Application: SSI 7485

I write regarding the proposed modification to M4-M5 Link, Mod 2 The Crescent overpass and changes to pedestrian infrastructure in North Annandale, Rozelle and Rozelle Bay Foreshore area.

Figure 4-2 Pedestrian and cyclist bridge infrastructure options

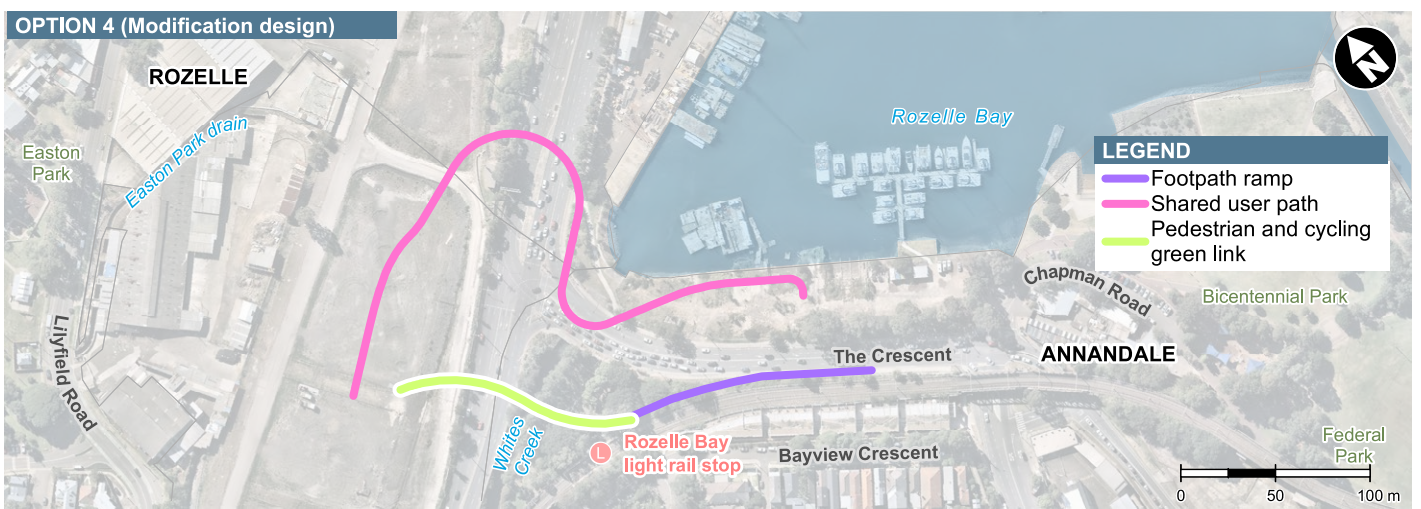
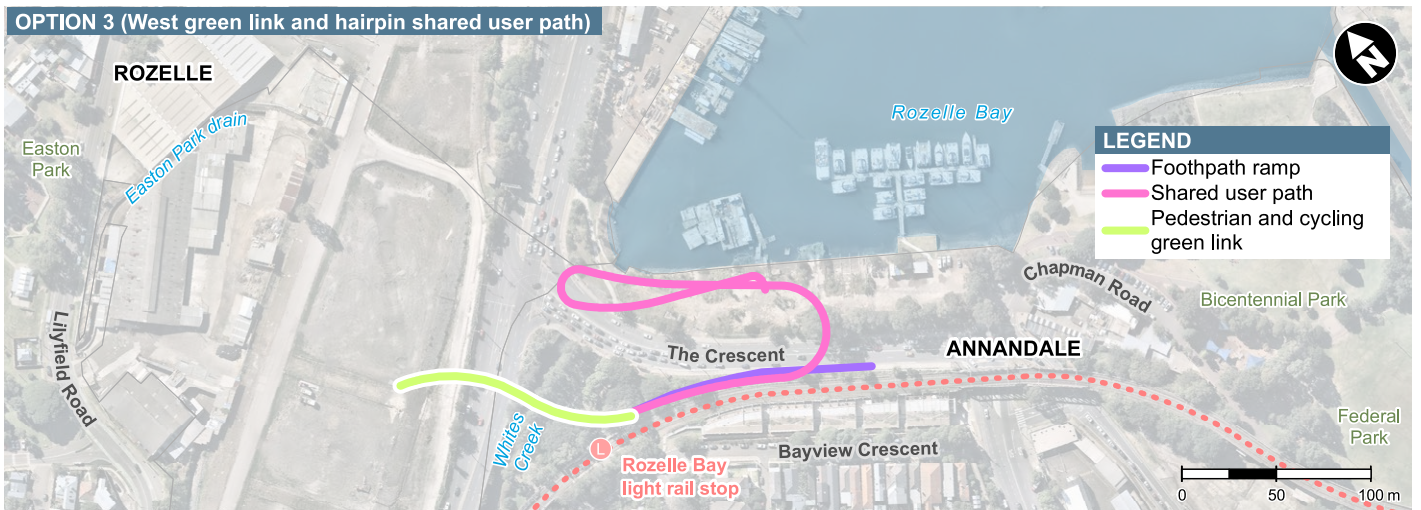
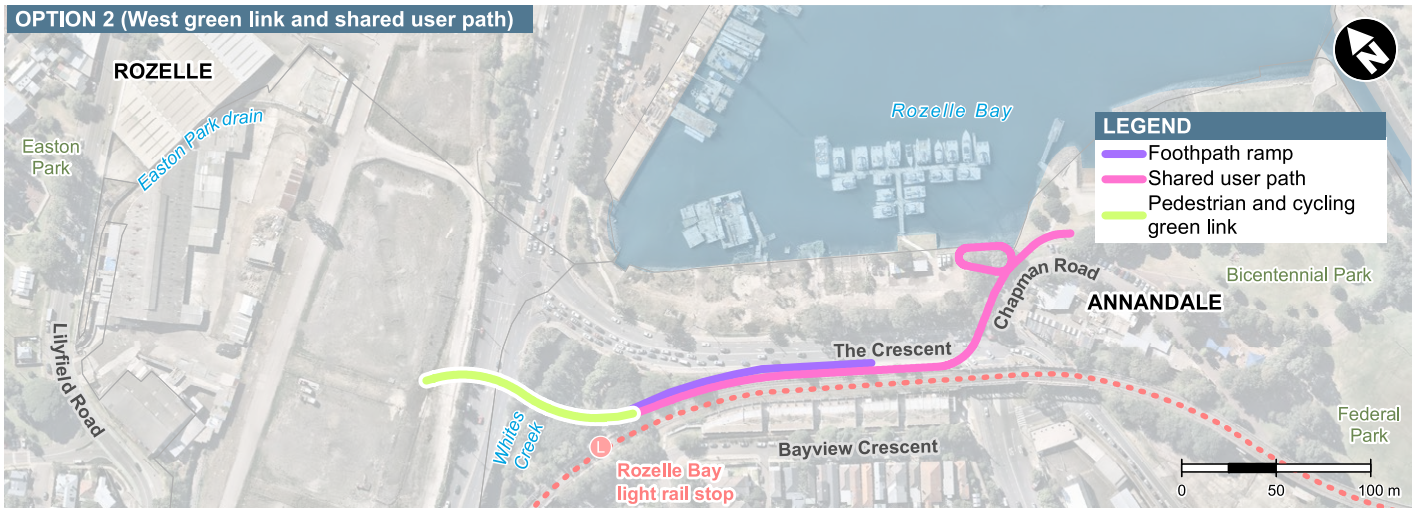
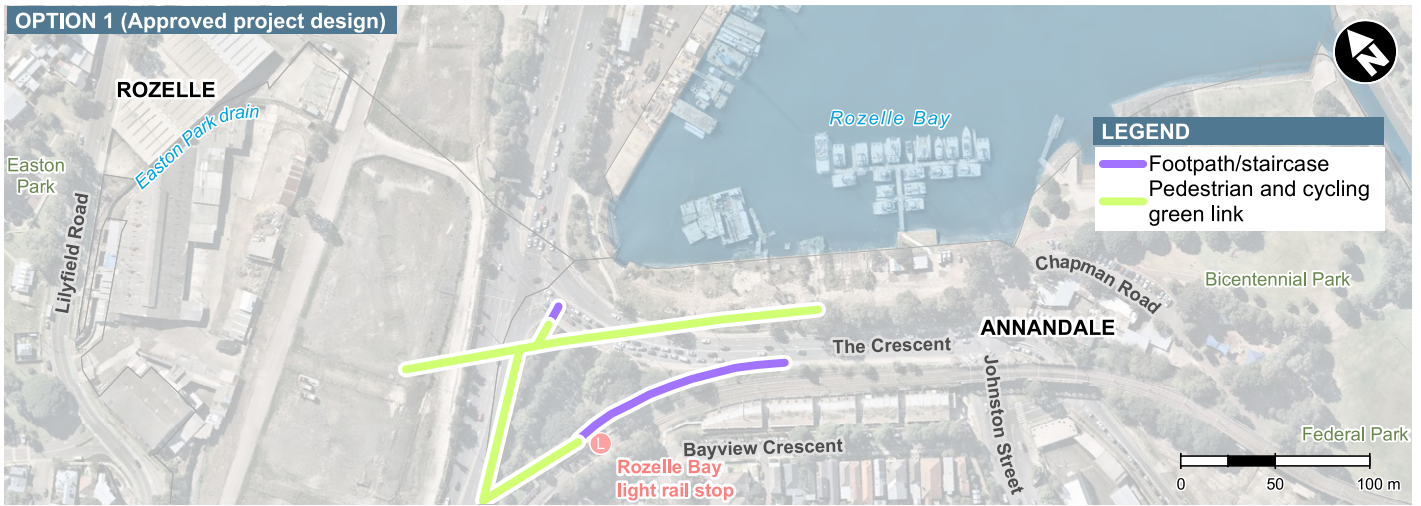
WHY CAN'T YOU MAINTAIN THE ORIGINAL DESIGN. IT WAS ELEGANT + SIMPLE WITH THE AIM TO FACILITATE PEDESTRIAN MOVEMENT.

INSTEAD YOU PROPOSE A CONFUSING, COMPLEX, CONTORTED + JUST PLAIN UGLY SOLUTION.

CAN'T YOUR TRAFFIC ENGINEERS DESIGN A MORE FRIENDLY + ACCEPTABLE SOLUTION, ESPECIALLY FOR PEDESTRIANS AT THIS BUSY ROAD WAY.
